KIRKLEES METROPOLITAN COUNCIL

UPDATE OF LIST OF PLANNING APPLICATIONS TO BE DECIDED BY STRATEGIC PLANNING COMMITTEE

10 May 2018

CHANGE OF USE OF LAND FOR BUSHCRAFT ACTIVITIES

Rev B 25/01/2018 Passing places added.		
Rev A 18/09/2017 Finalised prior to planning submission.		
Project Use of land for Bush Craft		
Address Off Warehouse Hill Marsden.		
Title Site plan and cross sections.		
Sheet size A1.	Drawing number ML 02 B.	Date Aug 2017.

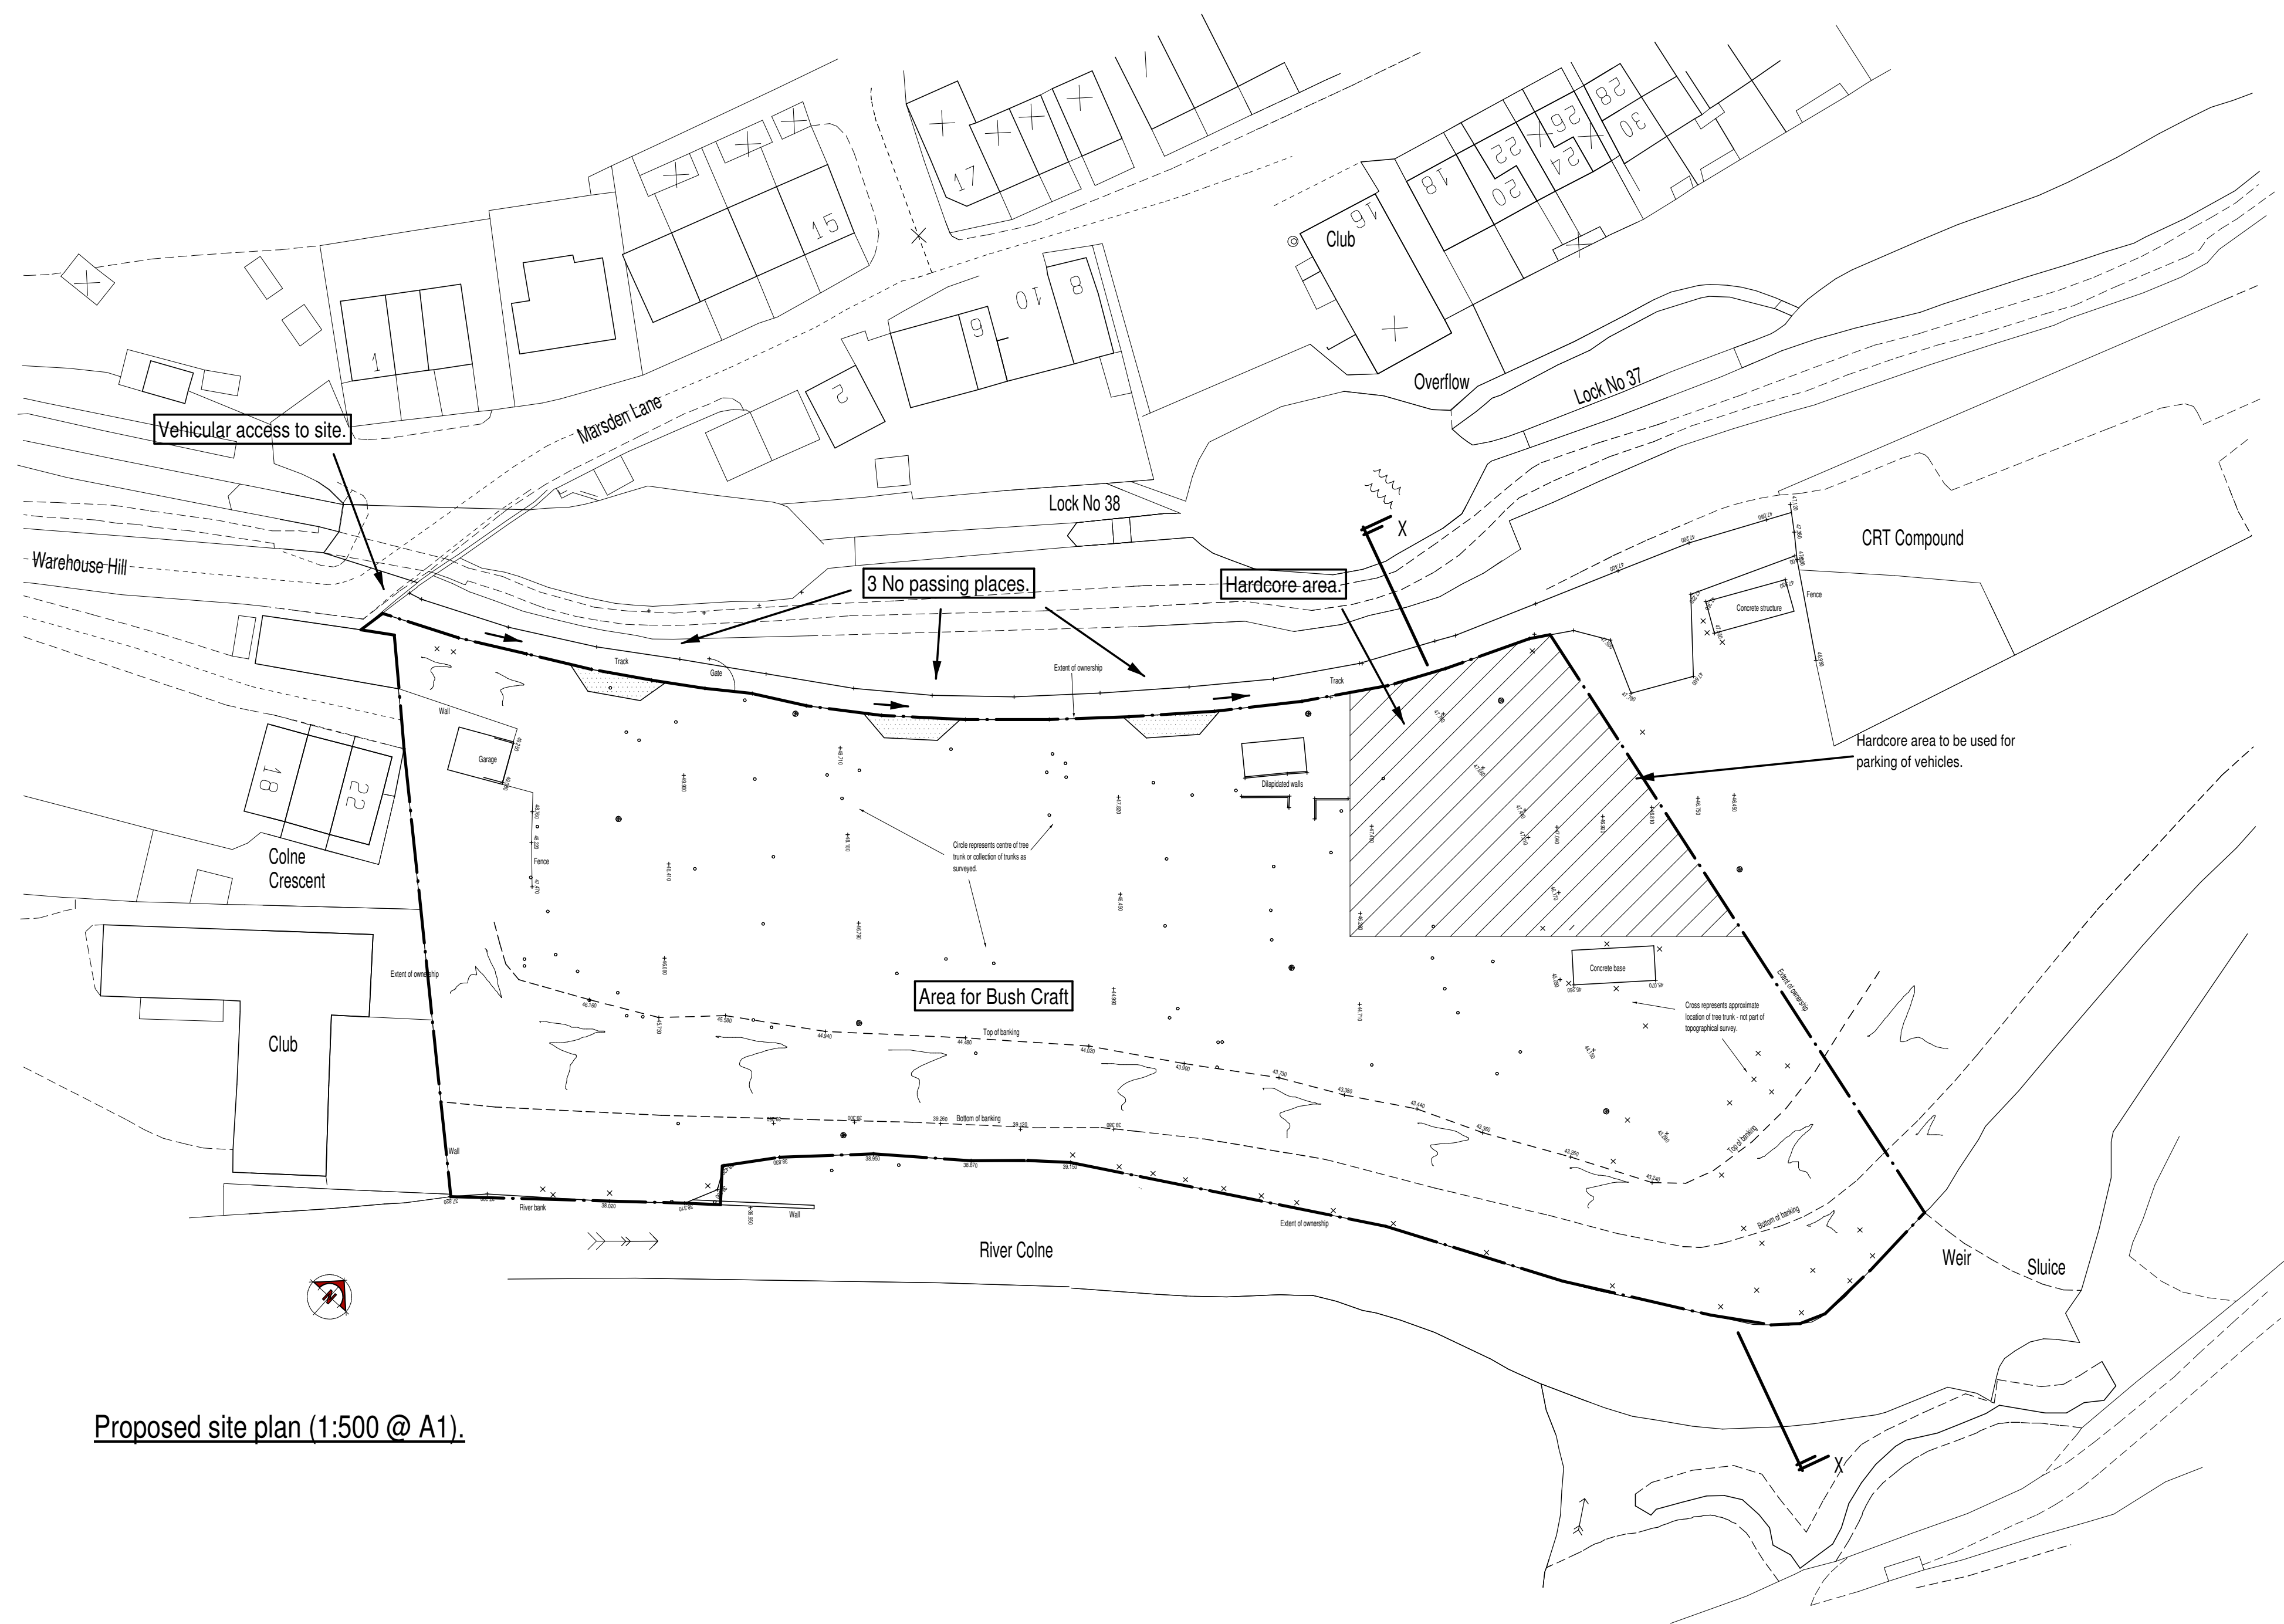
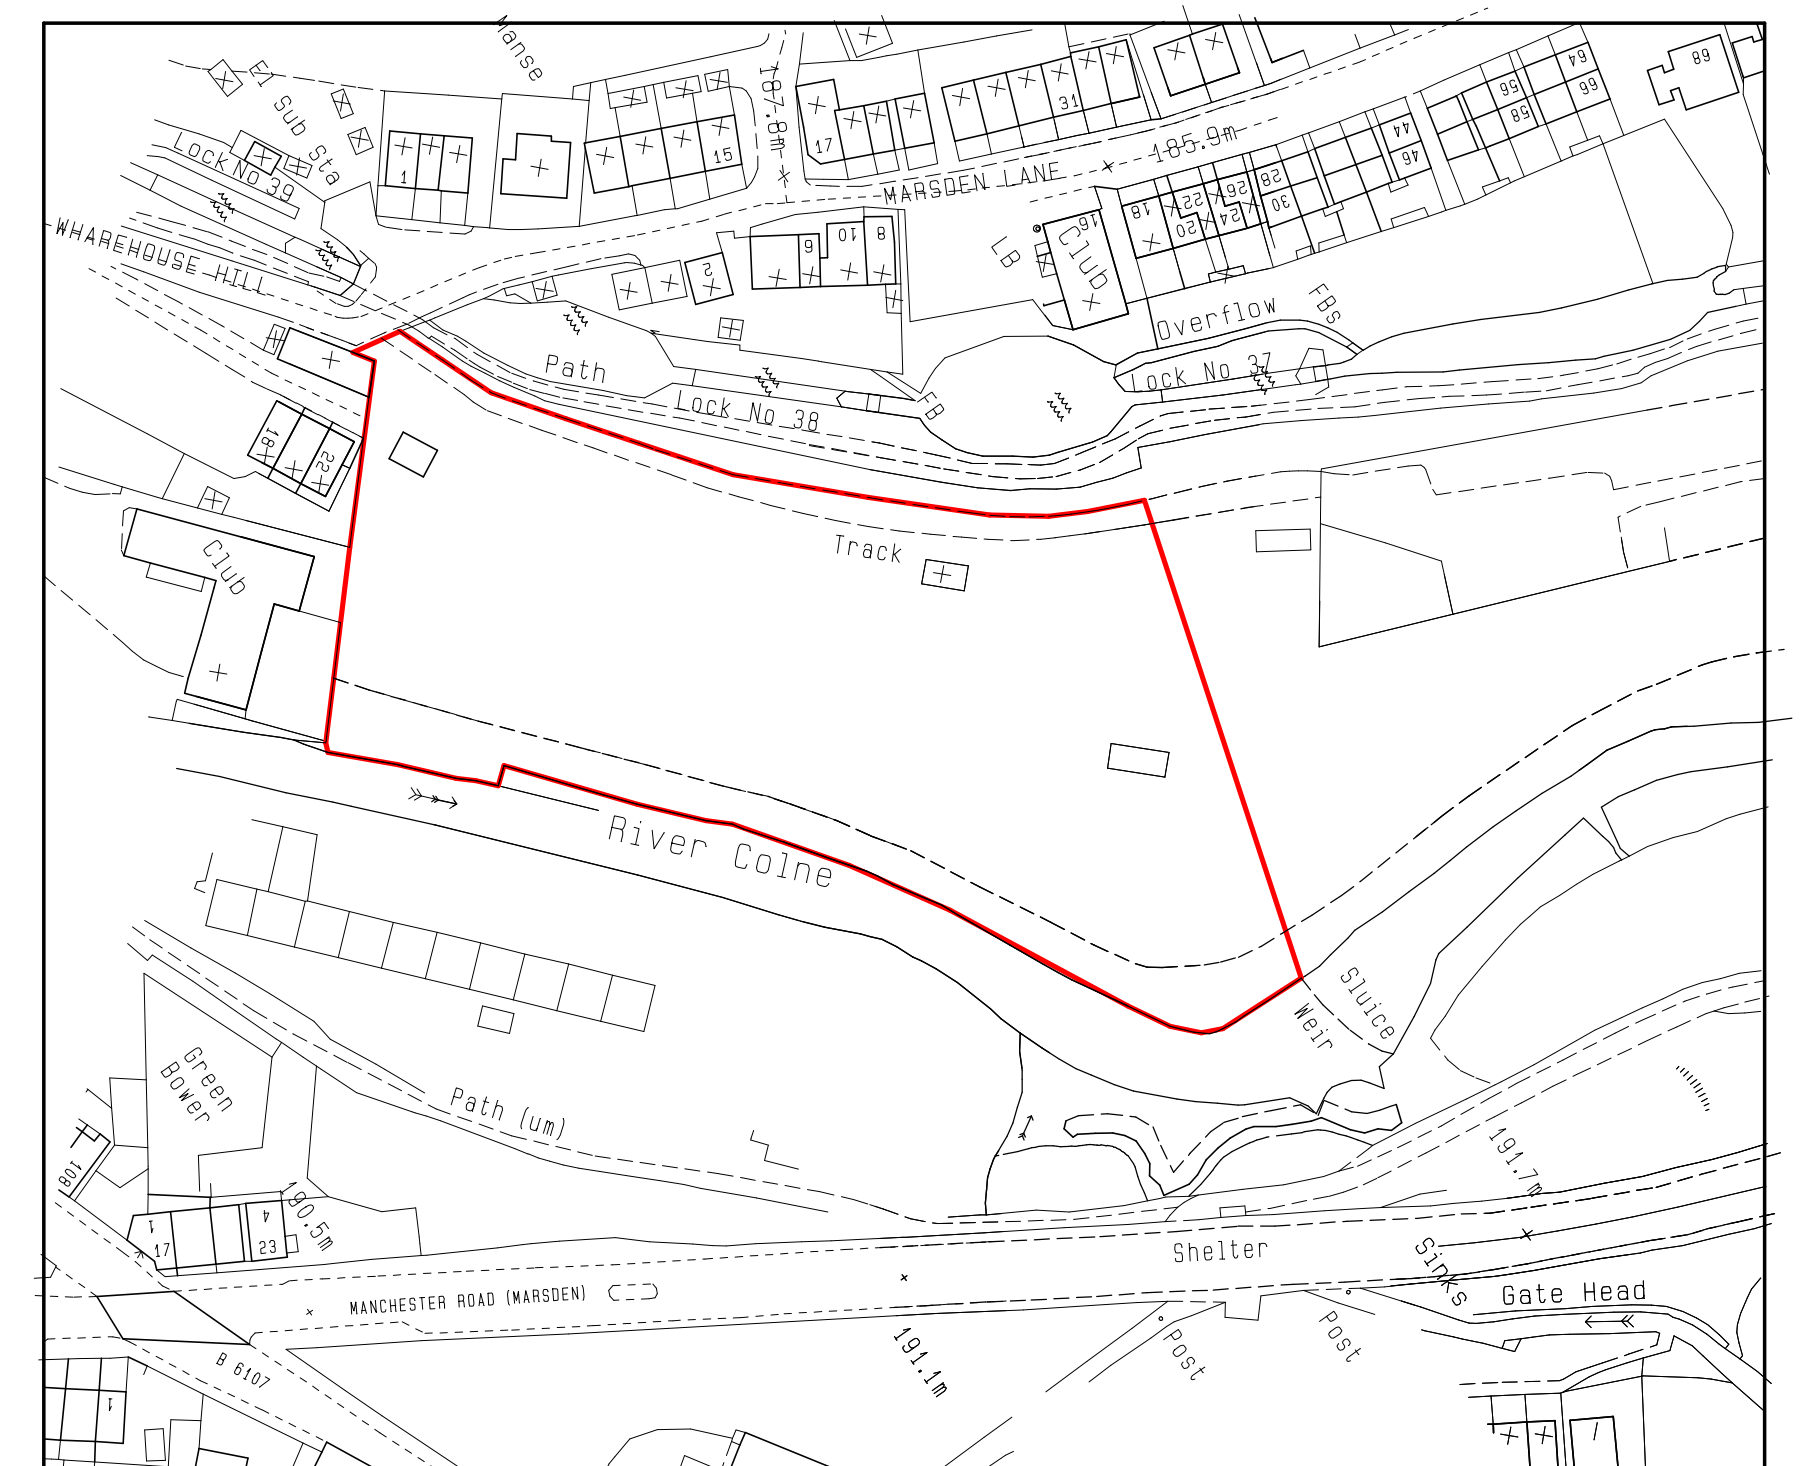
Further to the assessment set out in the published committee report, the Highway Officer has further reviewed the attendance numbers and patterns of visitors to the site and has advised that the site access requires improvements.

Discussions have taken place with the applicant and agent regarding this matter and an additional plan has been provided. The plan details that the entrance of the site will be widened to the south where it joins with Warehouse Hill Road/Marsden Lane with the removal of a 1.7 metre wide section of wall to improve access and egress into the site. The height of the access track will be increased along a 30 metre stretch to reduce the gradient with the greatest increase occurring to the first 10 metres and ensure that vehicles exiting are visible to passing traffic on the adjacent road. The plan also sets out that the first 5 metres will be hard surfaced and that internal turning for a mini bus within the parking area is achievable.

It is noted that the proposed access track improvements would require the formation of a retaining structure to the south of the track to support the increase in levels. The retaining structure would however be located within the application red line boundary and this arrangement is considered to be acceptable. It is acknowledged that the site is adjacent to the Marsden Conservation Area (though is outside its boundary) and would lead to the loss of a small section of wall. The loss of wall is minimal in terms of scale and it is considered that this would not lead to any detrimental impact on the setting of the Conservation Area.

The works to widen the access would also lead to the loss of some vegetation and a tree adjacent to the entrance. The loss of vegetation is considered to be minimal in terms of the wider scale of the site, and as set out in the published committee report whilst the site is occupied by a number of mature trees these are not worthy of a preservation order. The loss of an additional tree adjacent the entrance is therefore considered to be acceptable.

The further details have been assessed by the Highway Office who considers that the proposed improvements to the access are acceptable subject to a condition requiring the provision of the improvements before the use commences.

In light of the above the proposed conditions for the development have been amended to remove the conditions which have now been addressed and add conditions relating to providing the access improvements. A full set of proposed conditions is set out below:
